Appendix A – Schedule of Proposed Modifications

Proposed Modifications to COFA Approval MP 08_00831 (Modification 3)

project COFA Gateway  
drawing MAJOR CHANGES - BLOCK F - EAST & WEST ELEVATIONS  
drawing no. A7-01  
scale 1:200 @ B1  
project no 100245.00

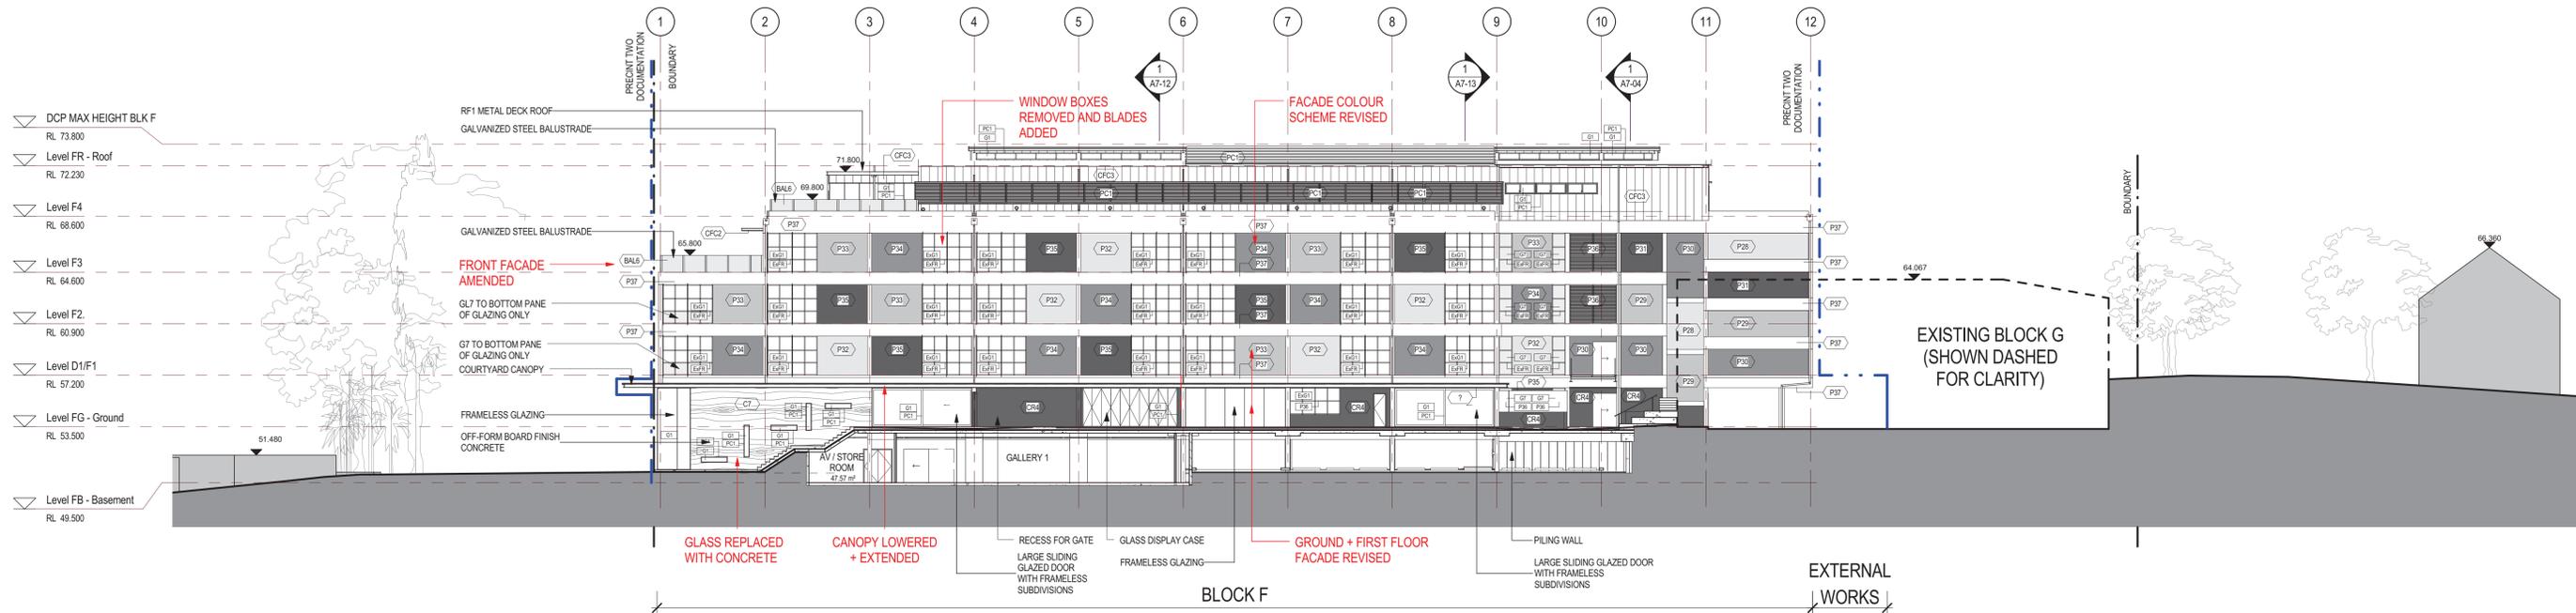
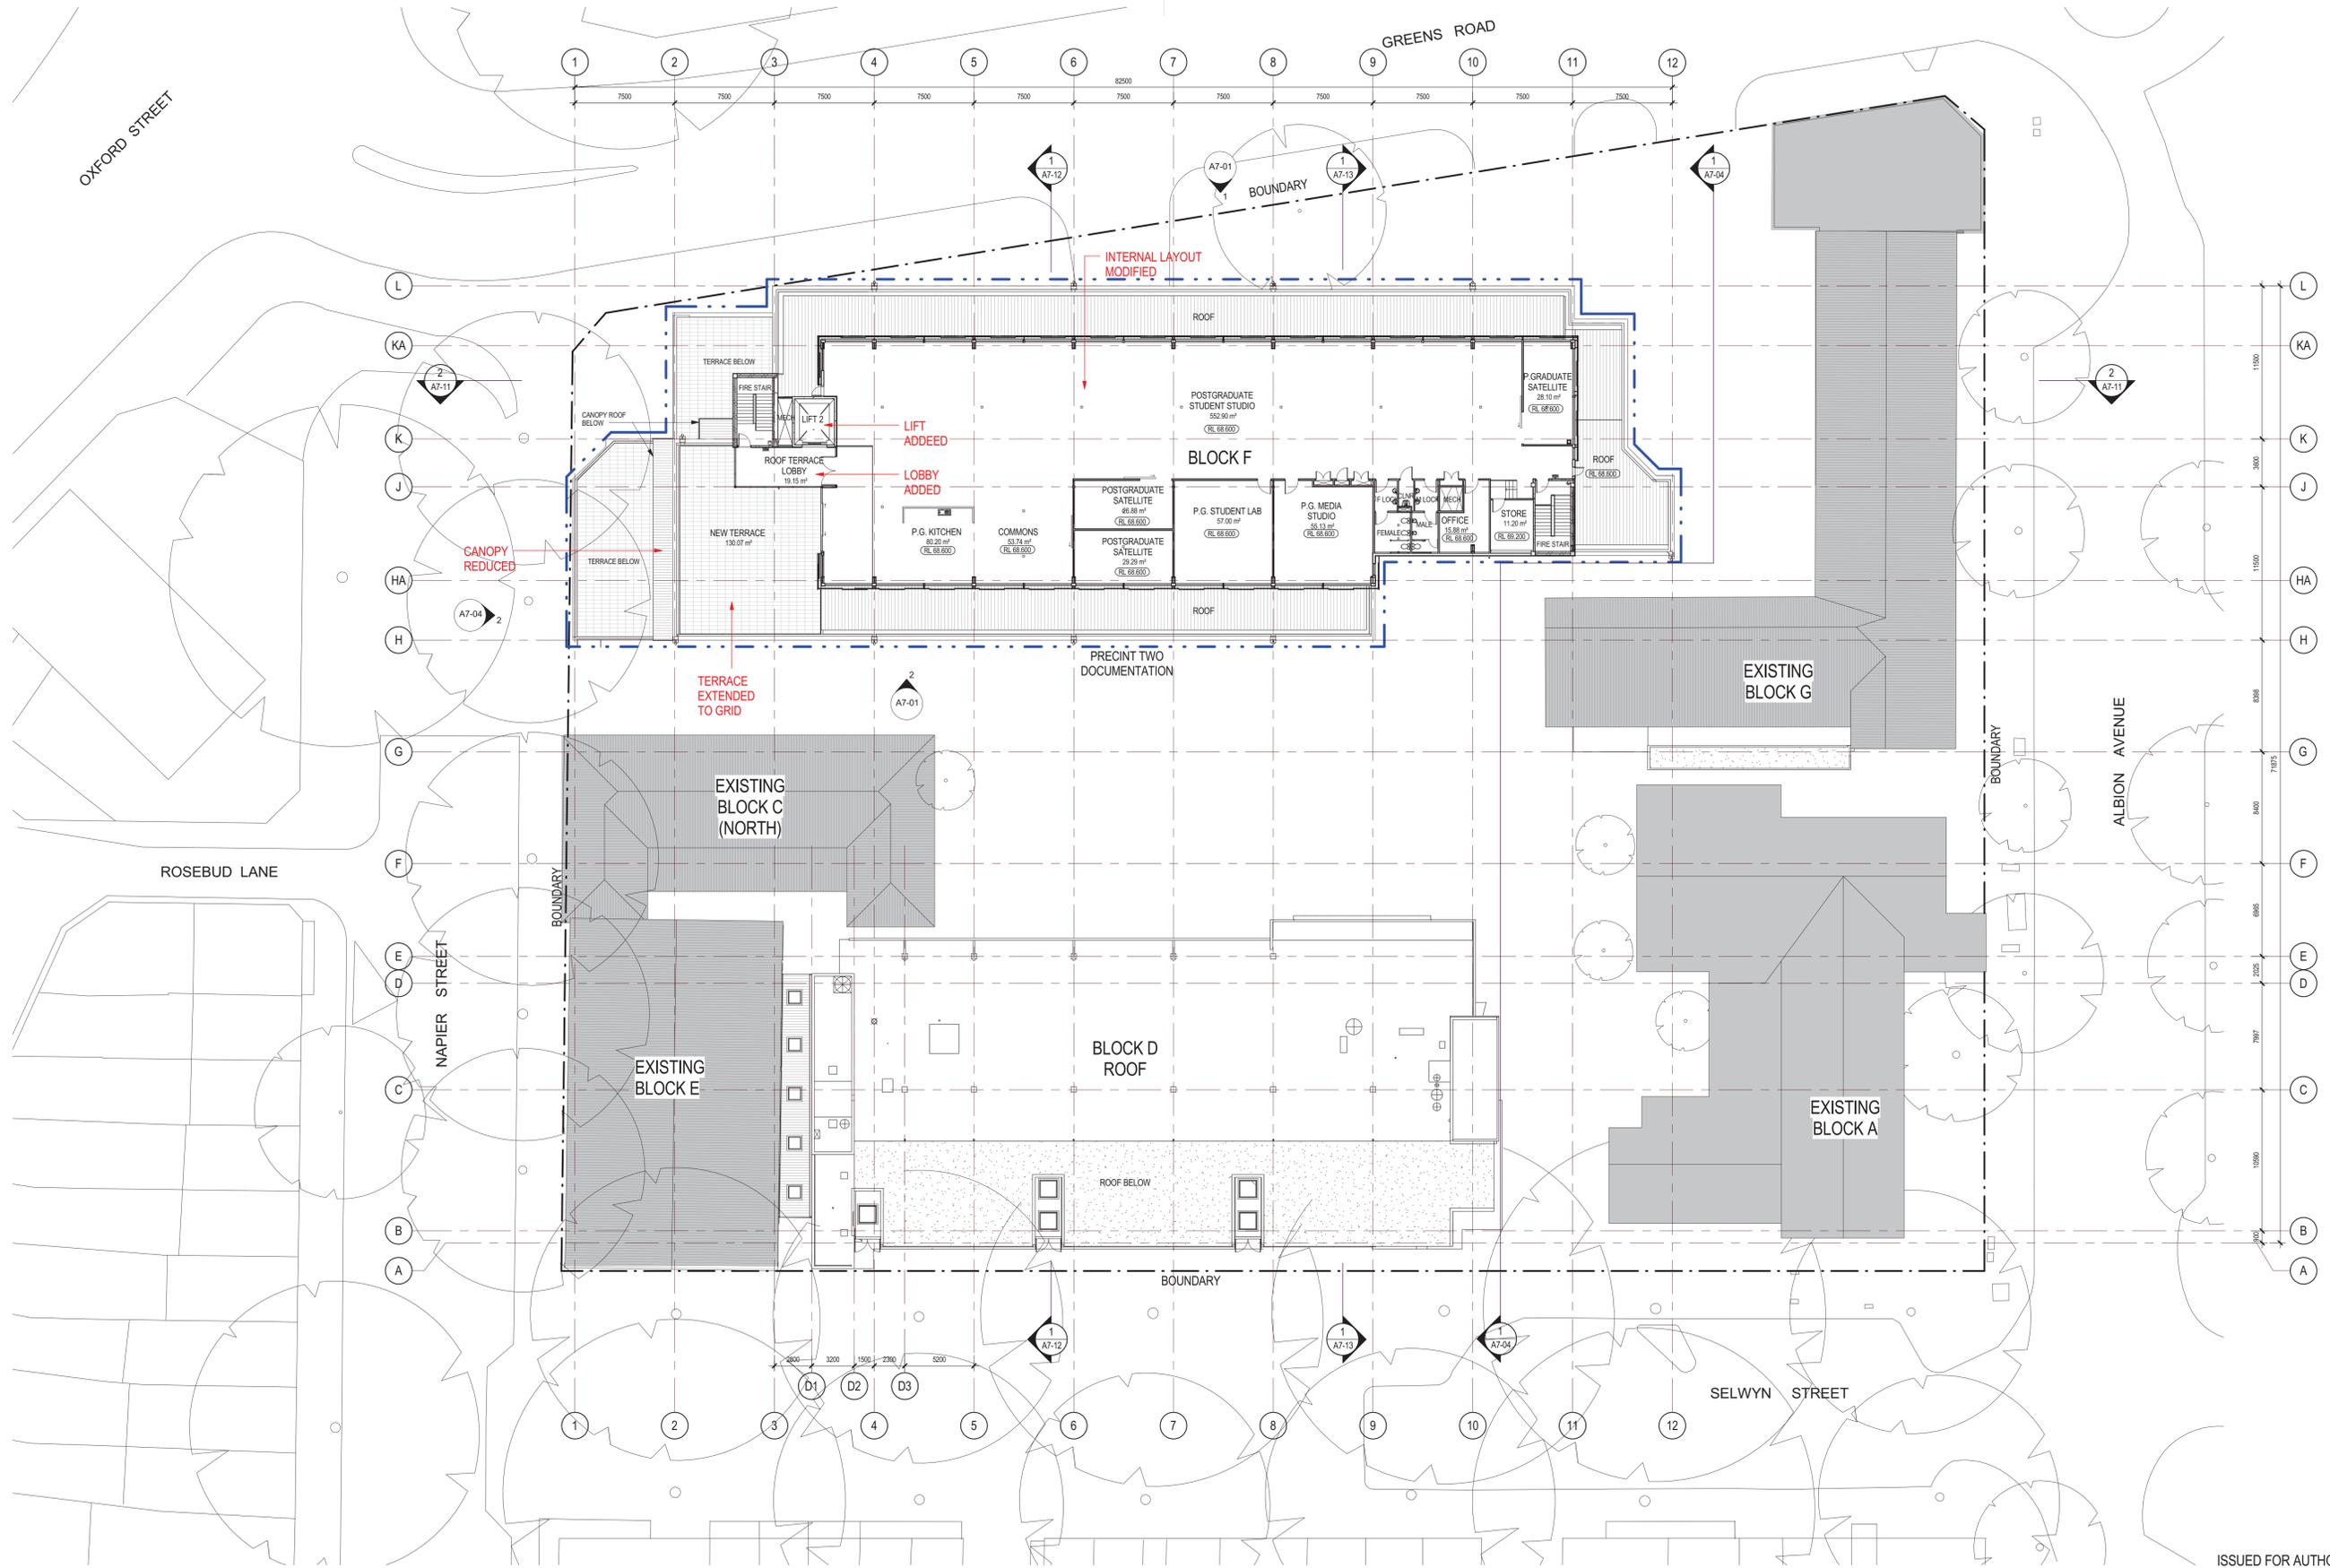
A2-01 B	A2-01 K	East and West Elevations (Block F)	<ul style="list-style-type: none"> Previously proposed art loading dock deleted Façade details changed Changes to materials and finishes. 	<ul style="list-style-type: none"> Design development. Drawing consistency 	Changed appearance of building but no adverse environmental impacts.
A2-04 B	A2-04 G	South and North Elevations (Block F)	<ul style="list-style-type: none"> Façade details changed Digital screen added to north facade Design development 	<ul style="list-style-type: none"> Design development. Drawing consistency 	Changed appearance of building but no adverse environmental impacts.
